Consultation Response from KC, Highways Development Management
2024/92281 Land adj, 17, Whitehall Road West, Birkenshaw, BD11 2LS
Erection of 23 dwellings
Date Responded: 28-11-2024. Responding Officer: Mark Berry Responding Ref: 8-10NW-10.
This application seeks approval to the erection of 23 dwellings at land adjacent 17, Whitehall Road West, Birkenshaw. The site access has previously been approved by application number 2020/92802 for 11 residential units (10 new plus one existing). The proposals are for a total of 24 units from the same point of access as previously approved by the 2020/92802 permission. The application is supported by a Transport Assessment (TA) prepared by Development Planning Ltd. This includes an assessment of the anticipated traffic generation as follows The TRICS database has been used to assess the anticipated traffic generation for the proposed 24 units (23 new plus one existing). The forecast two-way peak hour AM and PM traffic flows are 16 and 22 trips, an increase of 8 and 12 trips compared to the previously approved application. The TA concludes that there are no reasonable highway reasons for refusal of the application. Highways Development Manageme

CLIENT:	ORION HOMES		
PROJECT:	LAND ADJACENT TO 17 WHITEHALL ROAD WEST		
TITLE:	SWEEP PATH ANALYSIS REFUSE VEHICLE ACCESS (ENTERING)		
SCALE @ A3:	NTS	APPROVED:	DATE:
		DRS	27/06/2024
PROJECT No:	2024376	DRAWING No:	REV:
		DPL SK006	A
© Development Planning Limited

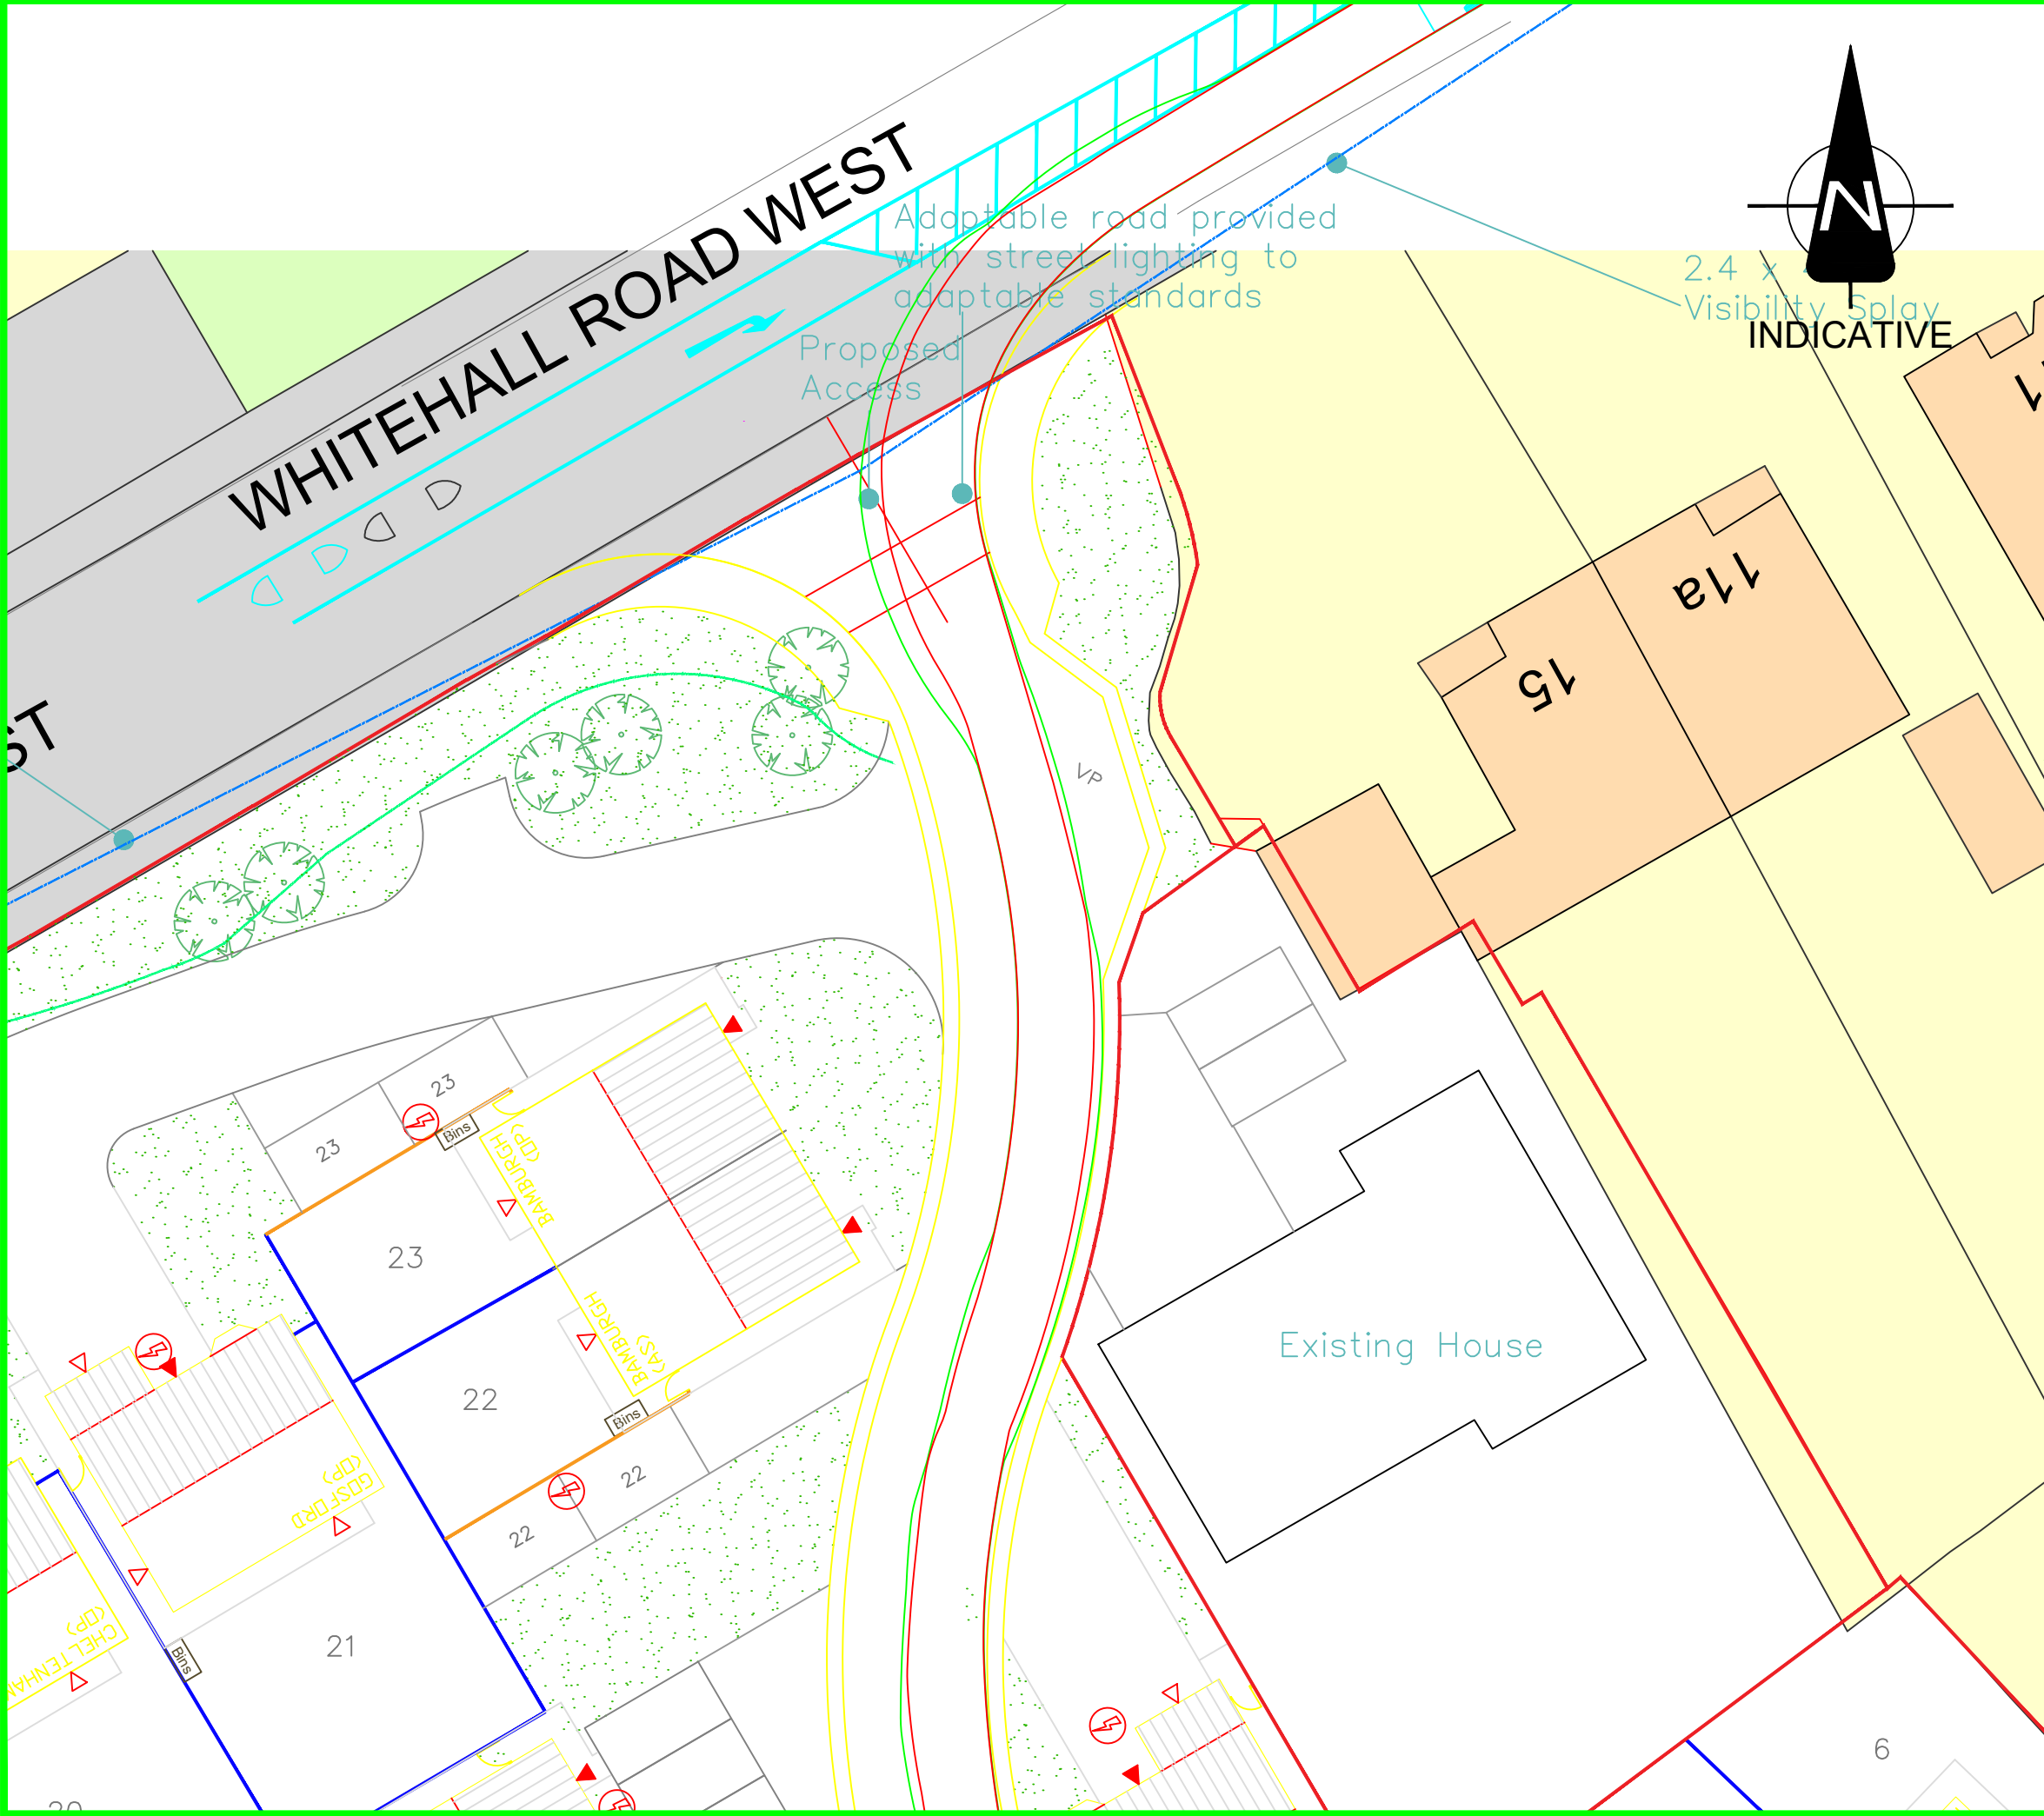
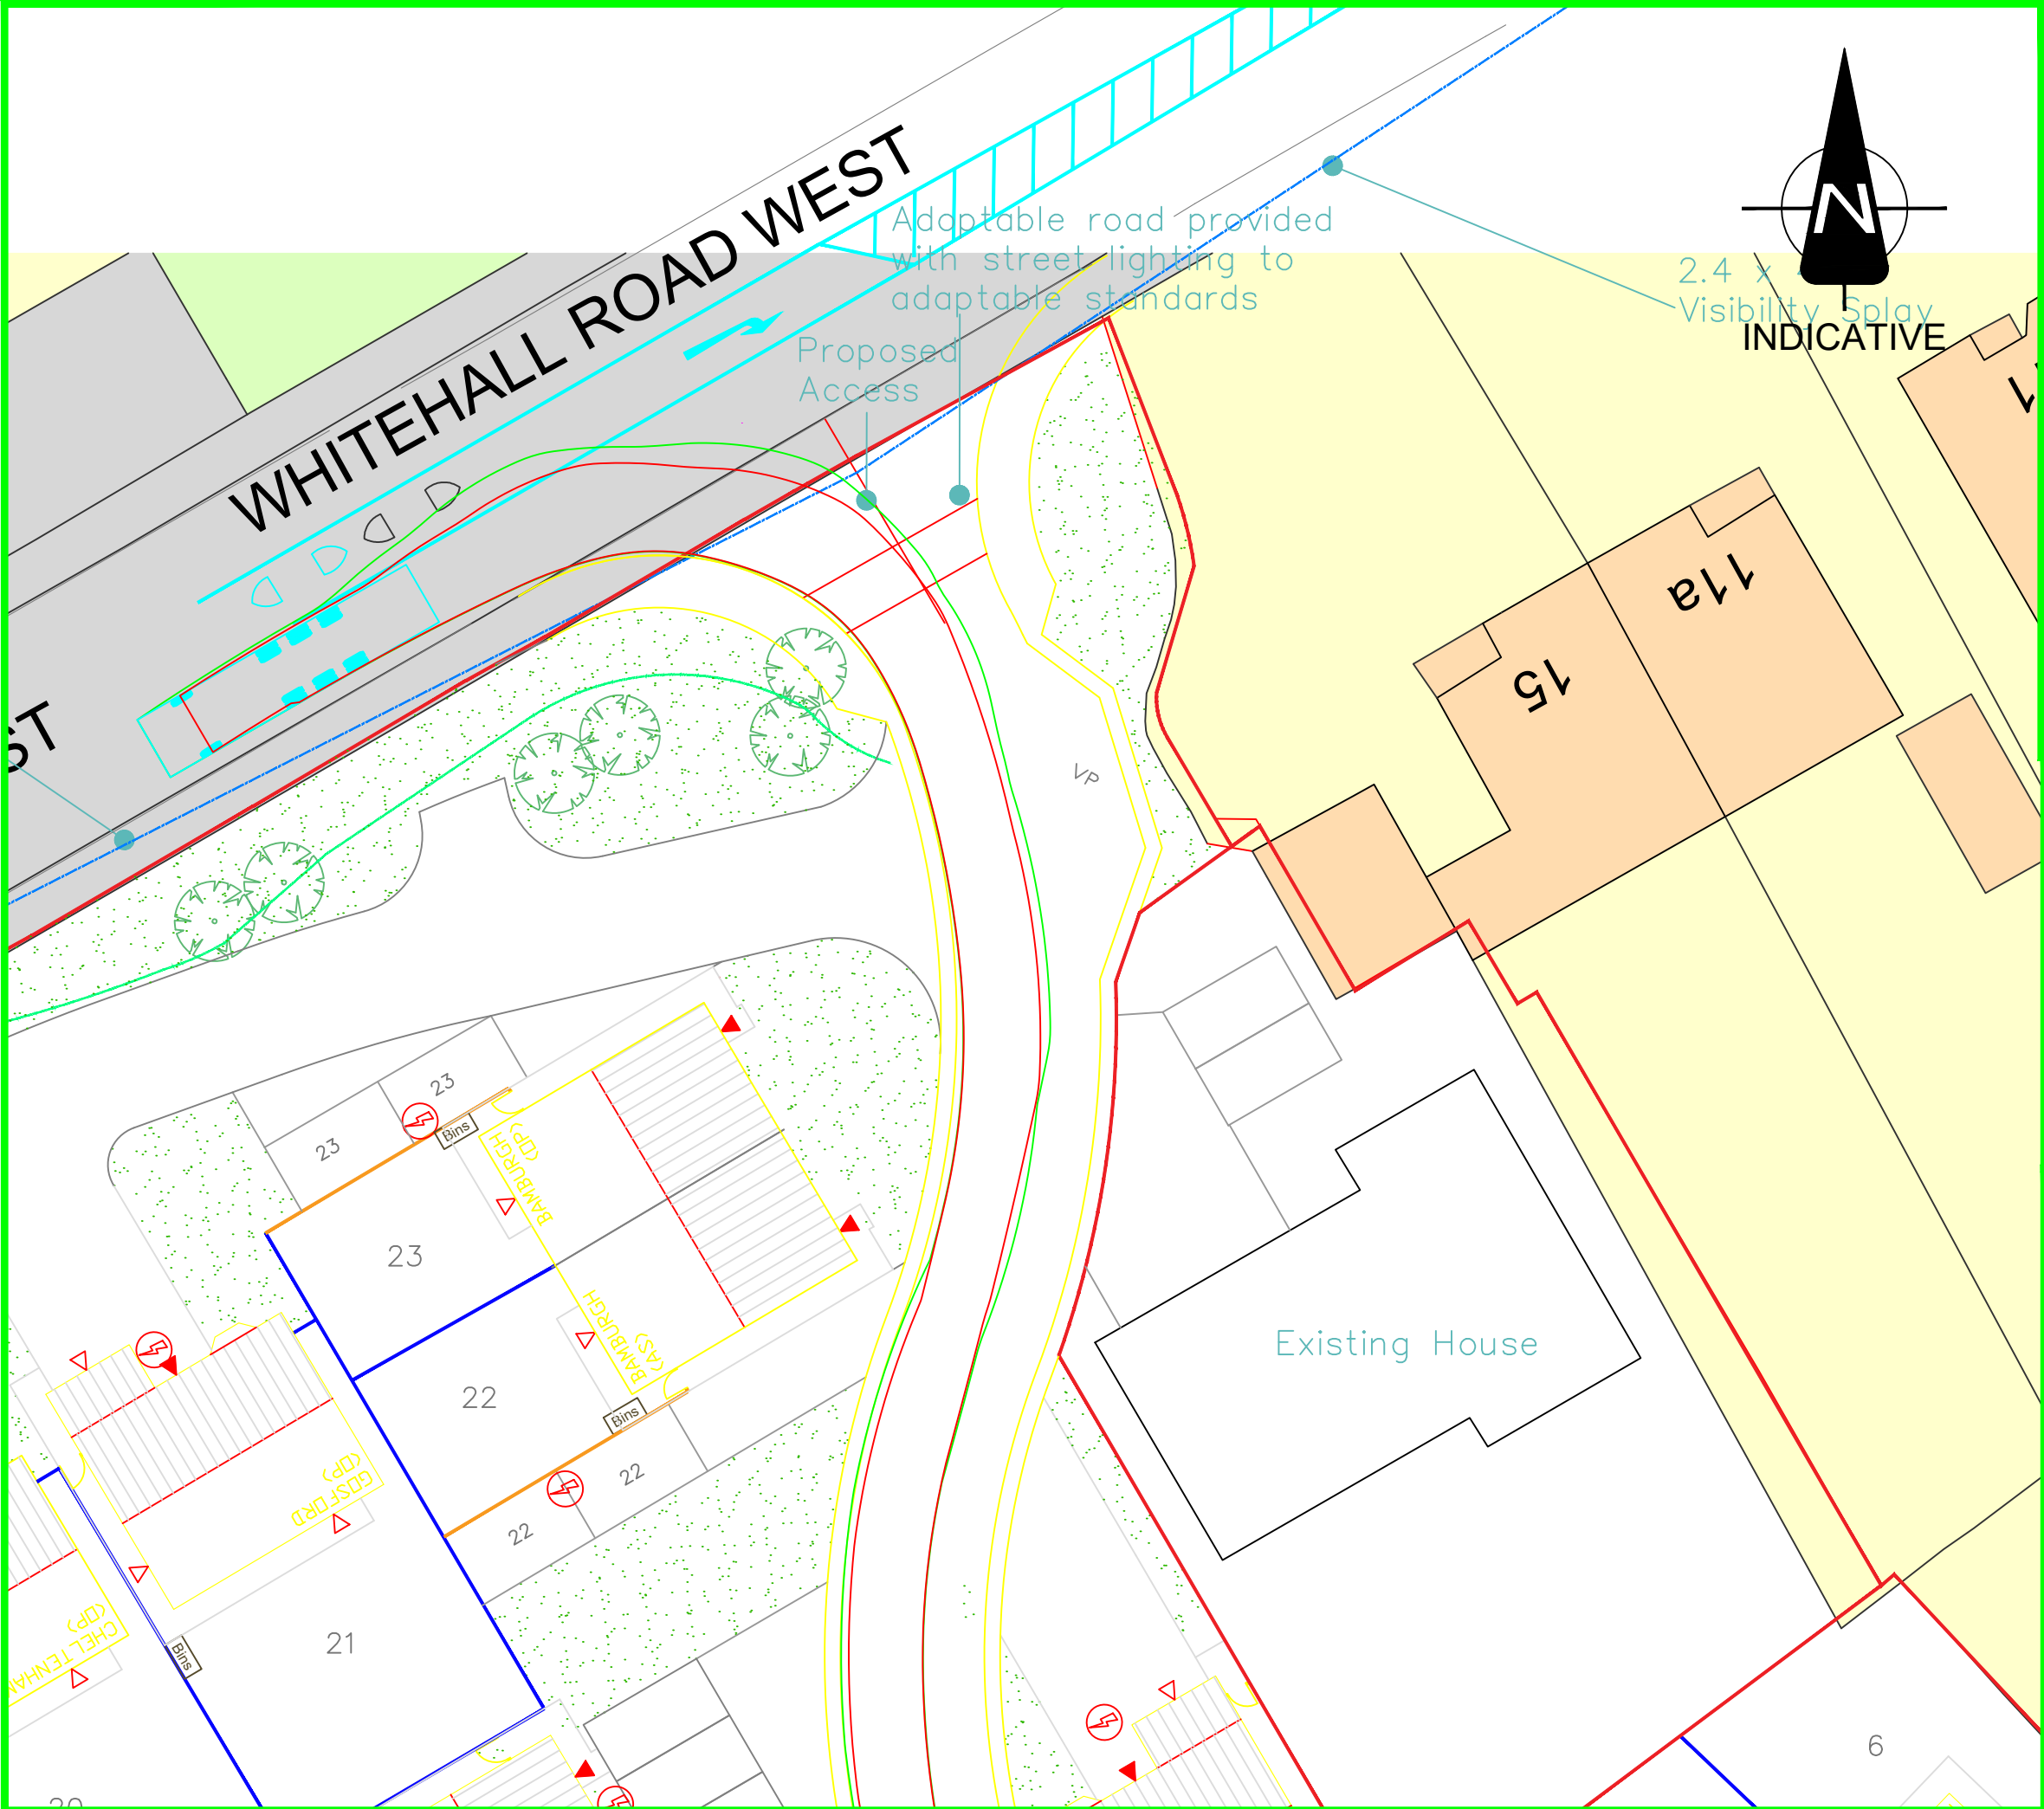
minimum standards.

Can the applicants also confirm the vehicle speeds when manoeuvring RCVs, shall be able to travel at a minimum speed of 5 km/h forward and 2.5 km/hr reverse. In other words, drivers shall not need to stop to adjust the steering while stationary before setting off again.
